ISH 2 Hearing Action Points

London Pilots Council (LPC) Submission

15th January 2019

Drawing file: EN010084 / EN010084-000645-6.4.10.2_TEOW_Pilot_Transfer_Bridge_Simulation_Report.pdf

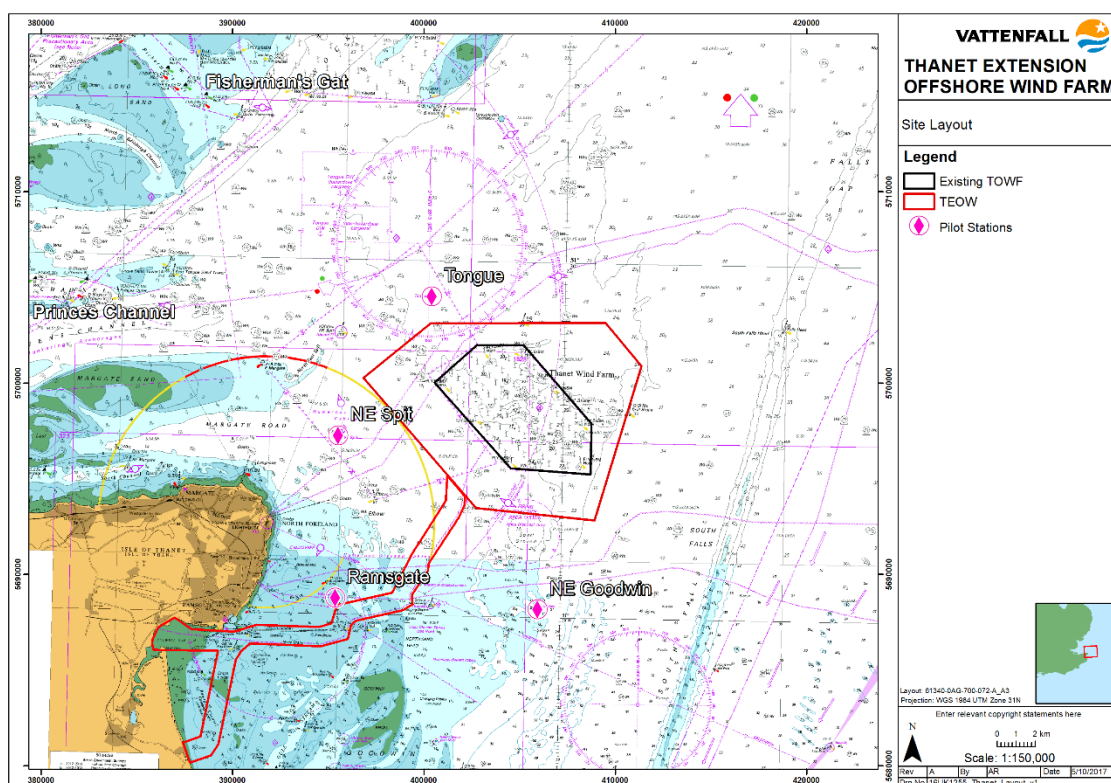
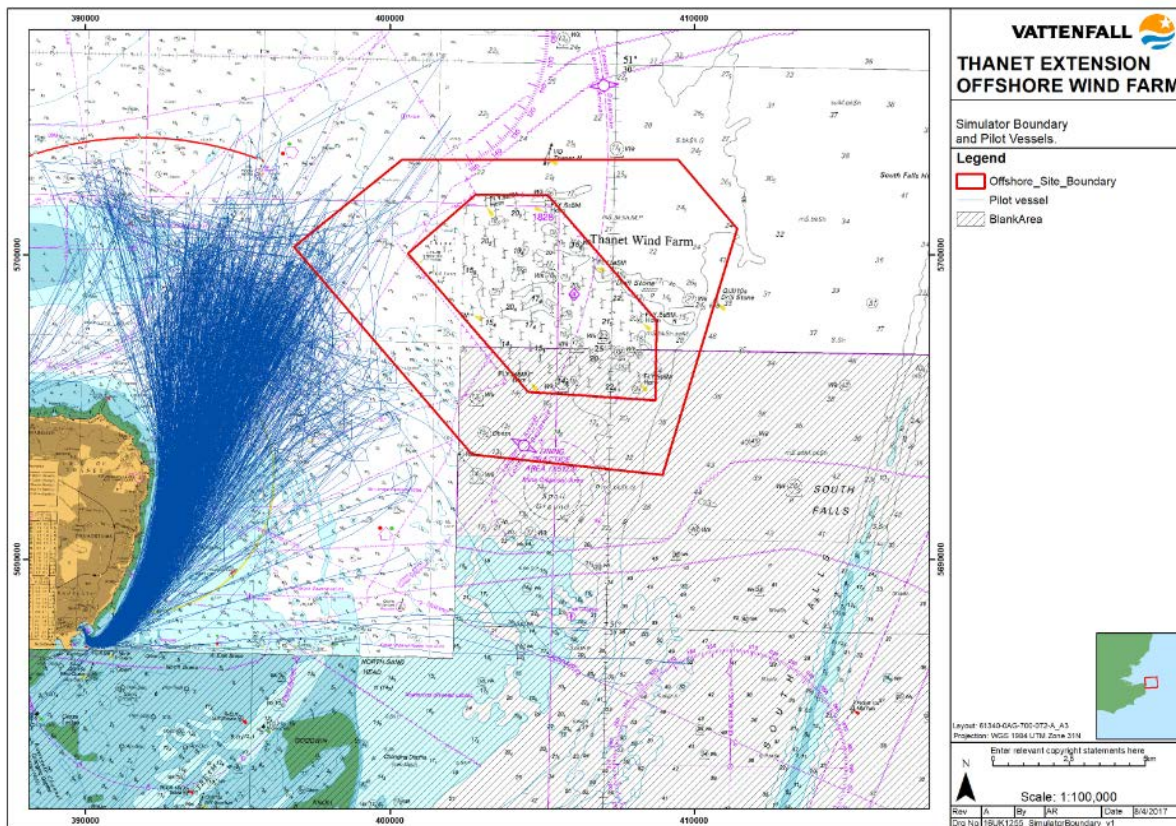
17.1. The Pilot Transfer Bridge Simulation Report is of very limited value. The LPC can clearly demonstrate that the trial runs were made at the most opportune states of tide and without regard for professional best practice or regard for SOLAS V passage planning requirements. The quality of the PLA simulator as the sole provider of data for such a critical decision on the safety of navigation during Pilot operations is distinctly questionable.

17.2. The report suggests unsafe practices such as routing large vessels which are constrained by their draft to transit over the NESP bank. As this manoeuvre would only be possible at certain states of tide close to high water, then in practice vessels would incur lengthy and costly delays whilst awaiting such tidal conditions. It is wholly unrealistic to expect a Grande type vessel of the type shown in the Report to delay for up to 6 hours. (See Fig.5)

17.3. The report ignores the IALA Buoyage system and other Navigation aids which are in place at the NESP to ensure safe navigation within the sea area. In particular these are the NESP Racon East Cardinal Mark and the North Foreland Sector Light. Instead the Report calls for special traffic management measure to assist vessels and “organise traffic” between the Northwesterly extent of the proposed Windfarm and the “Shoal water of the North East Spit”

17.4. The vessel is required by SOLAS V to prepare a Port to Port passage plan. Within that plan there are depth safety contours highlighted on the vessels ECDIS. The vessels Bridge Team expects the Pilot’s passage plan to roughly concur. The Prudent Master would certainly be questioning the safety of the passage when the Pilot suggests taking a large vessel, deep drafted in relation to the available depth of water, to the West of an East Cardinal Mark (denoting clear water to the East) and into the ‘Danger / Red Sector’ of the North Foreland light.

17.5. The Report advocates reducing the size of the Margate Roads Anchorage in order to increase available sea room. This is a very busy Anchorage and a Safe Haven. Typically vessels would be waiting for orders or berth availability. It is particularly busy during periods of strong winds, offering excellent shelter from the predominately South Westerly winds. The sea room in the navigable channel will reduce by 50% if the proposed extension goes ahead. It is of no surprise that the Applicants advocate a reduction in size of the Margate Roads anchorage, allowing more sea room for safety, contingency planning and traffic density. Several of the vessel trial runs in the simulation Report show vessel tracks manoeuvring at the very Eastern extent of the anchorage or very dangerously, just into the anchorage.

17.6. The capability of the PLA simulator is severely restricted and can only at best be indicative and should not be relied upon to give conclusive results sufficient for the Applicants purposes.

- The simulator was unable to reproduce the existing Windfarm
- The simulator was unable to reproduce the proposed extension.
- Junior Pilots of Class 4 and Class 3, less experienced Pilots were not included in the simulation trials
- The Pilot boat was substituted by a Tug model.
- Whilst speed may have been replicated, the tug simulator does not have radar
- It is disputed how simulations in restricted visibility were conducted without radar
- Without an operational radar then AIS targets such as Leisure craft and some fishing vessels etc. could not be plotted by ARPA. This is a non compliance with the COLREGS.
- No reductions in UKC for squat and swell were used or recorded

Sea Zones Plan – Reduction in red line boundary

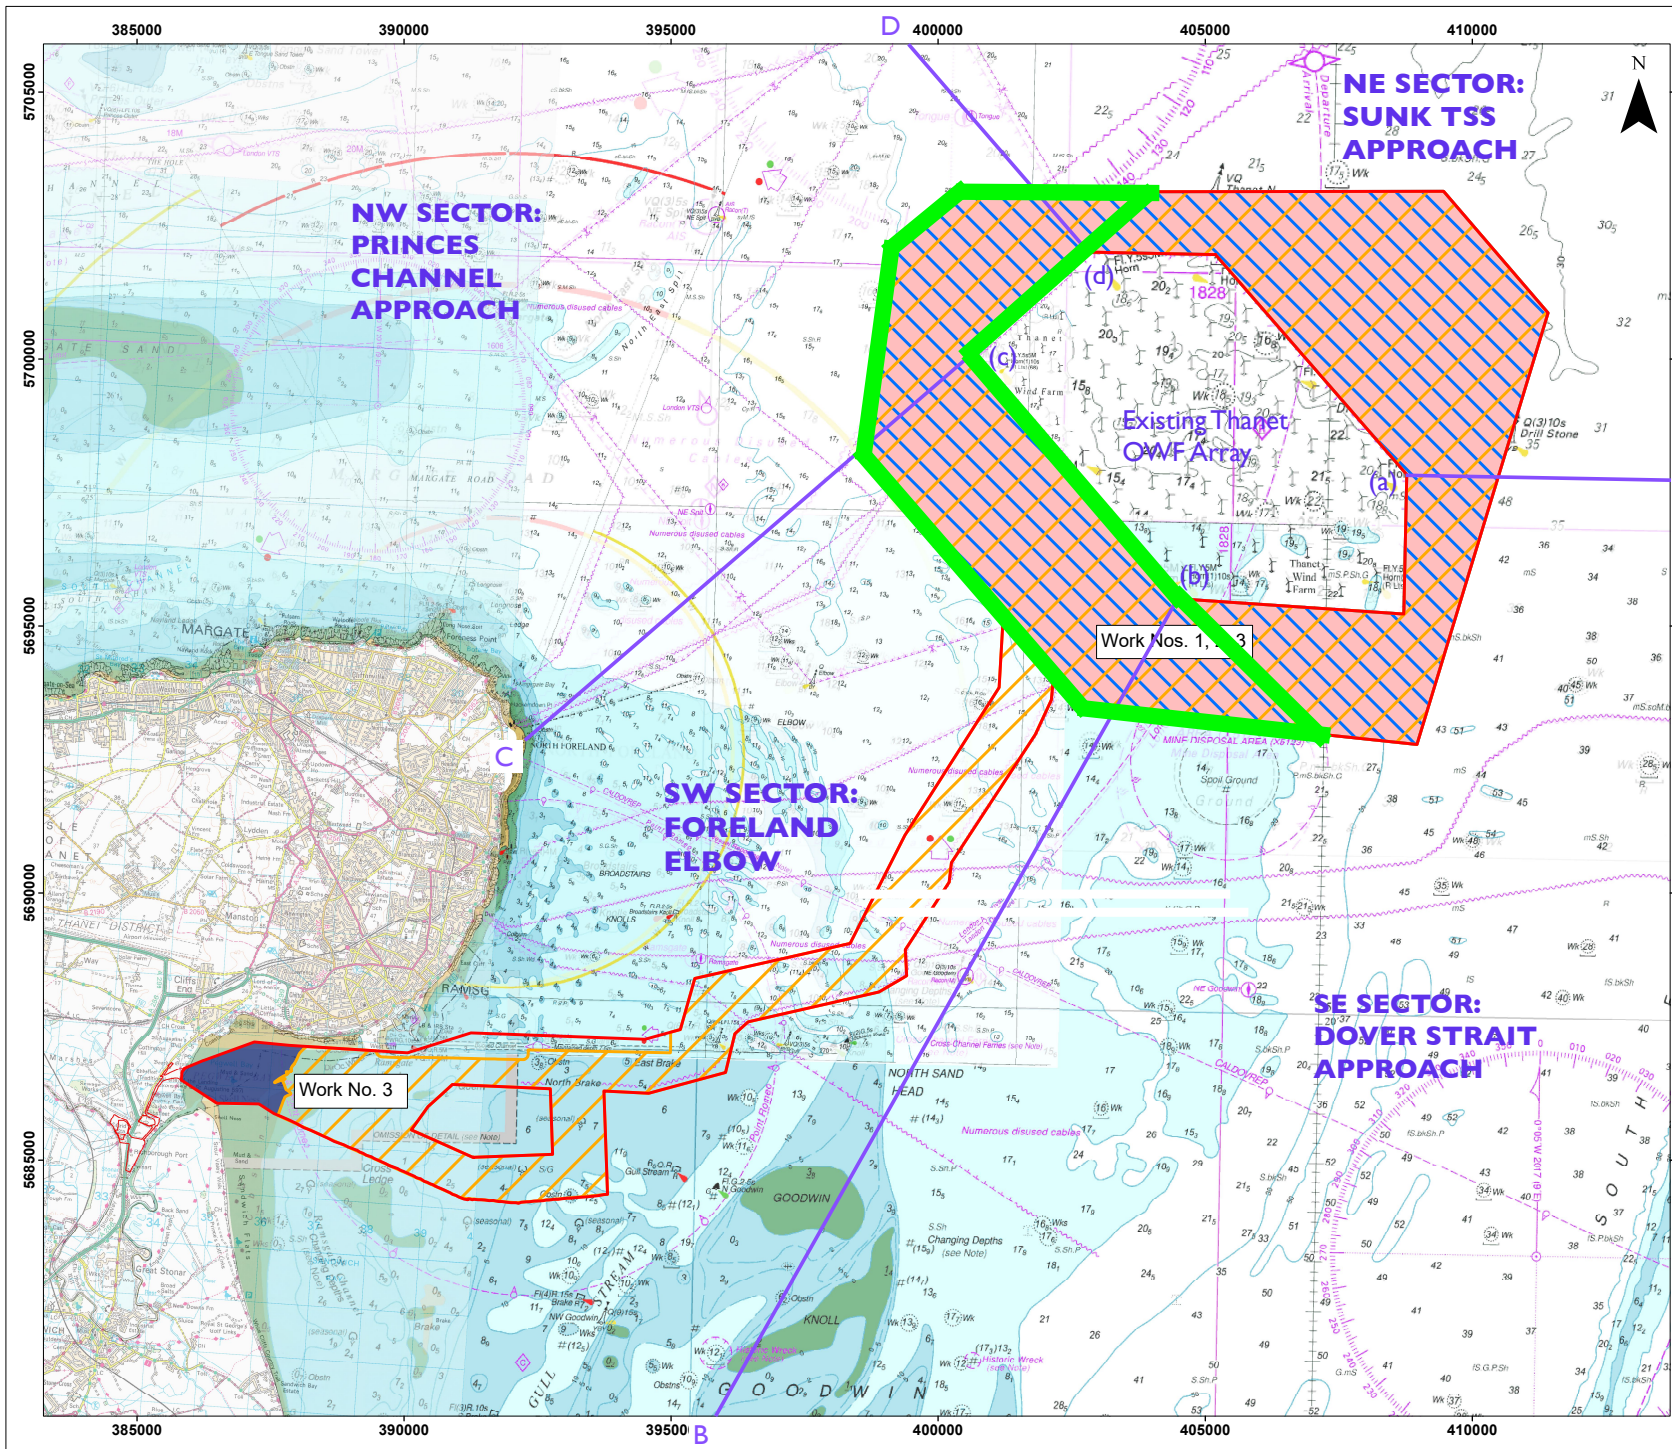
vi Fig. 1. The LPC requests that the Western boundary of the planned extension is removed as shown by the hatched/ shaded area shown in Fig.1
